Application for a non-material amendment following a grant of planning permission.

Two storey and single storey front extensions to create double gabled frontage, first floor side extension, part two storey and part single storey rear extension to a detached family dwelling, alterations to external materials and creation of a carriage driveway including new vehicular crossover.

Reference number:	<input type="text" value="19/2404/FUL"/>
Date of decision	<input type="text" value="06/02/2020"/>

Drawing No:  
P-102

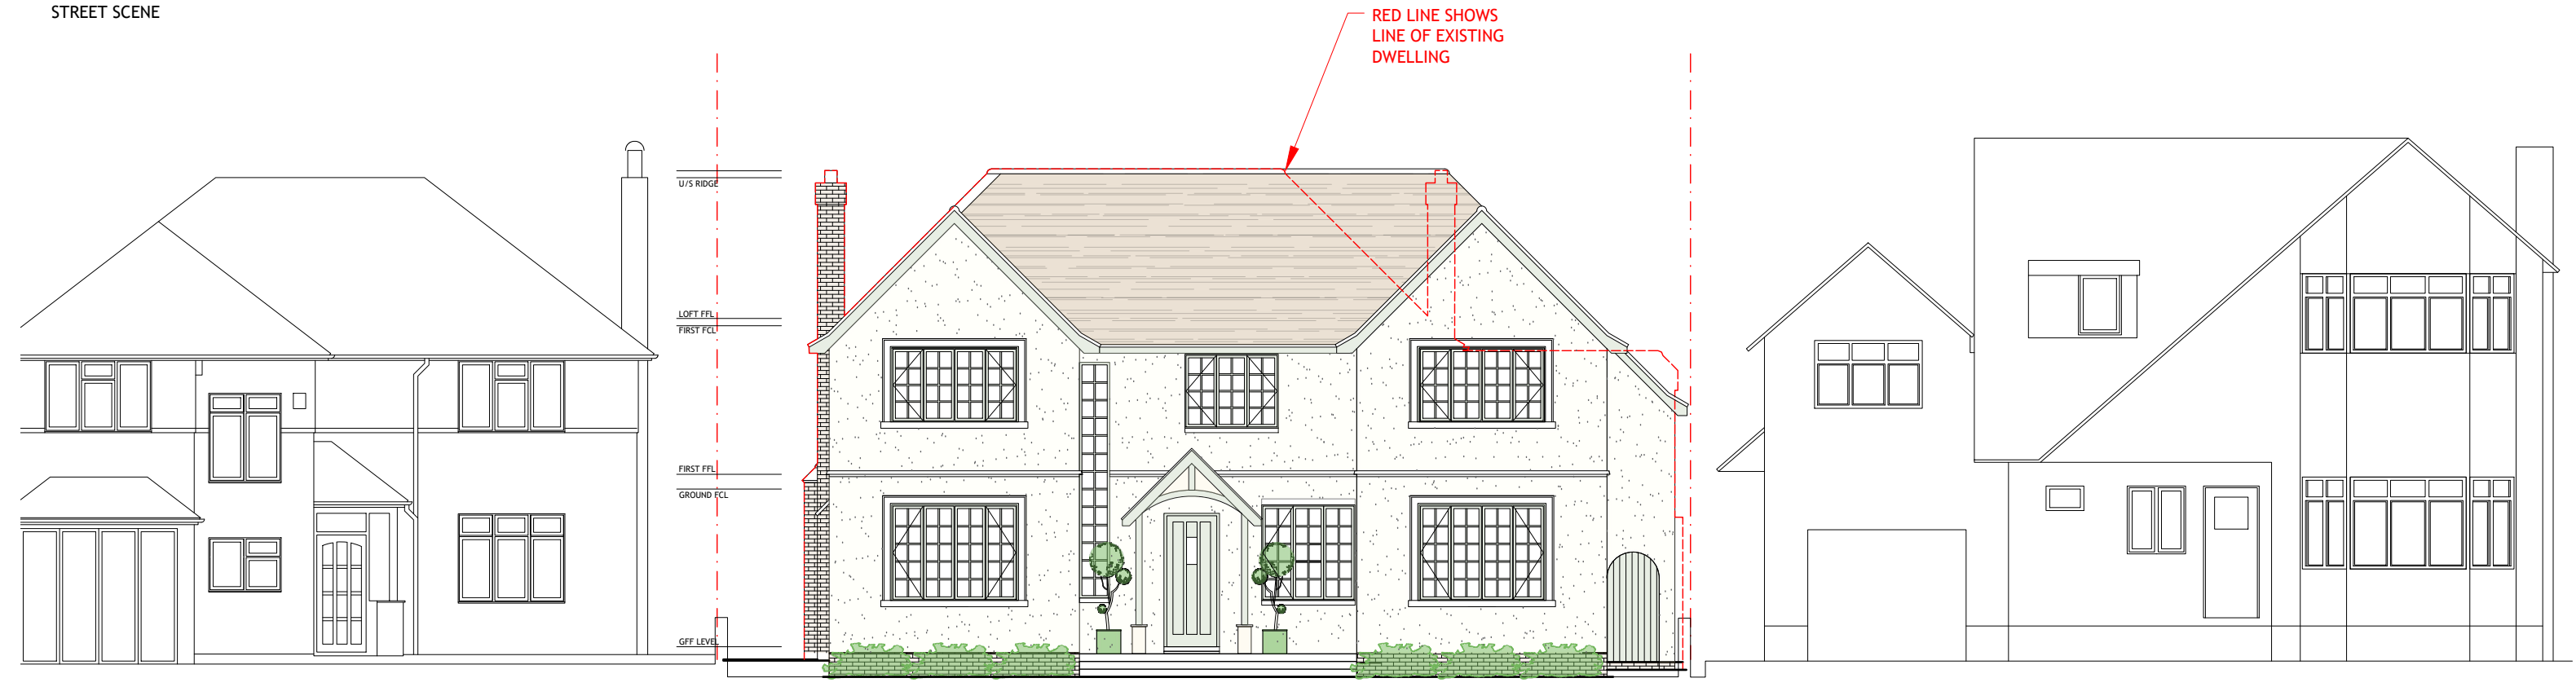
- Proposed garage on the front right hand side (when viewed from the front) of the property to be amended to a study and bicycle store, with the previous garage door being replaced with a window to match the other proposed gable.
- Proposed Kitchen door on the left hand side (when viewed from the rear) be amended to a smaller window.
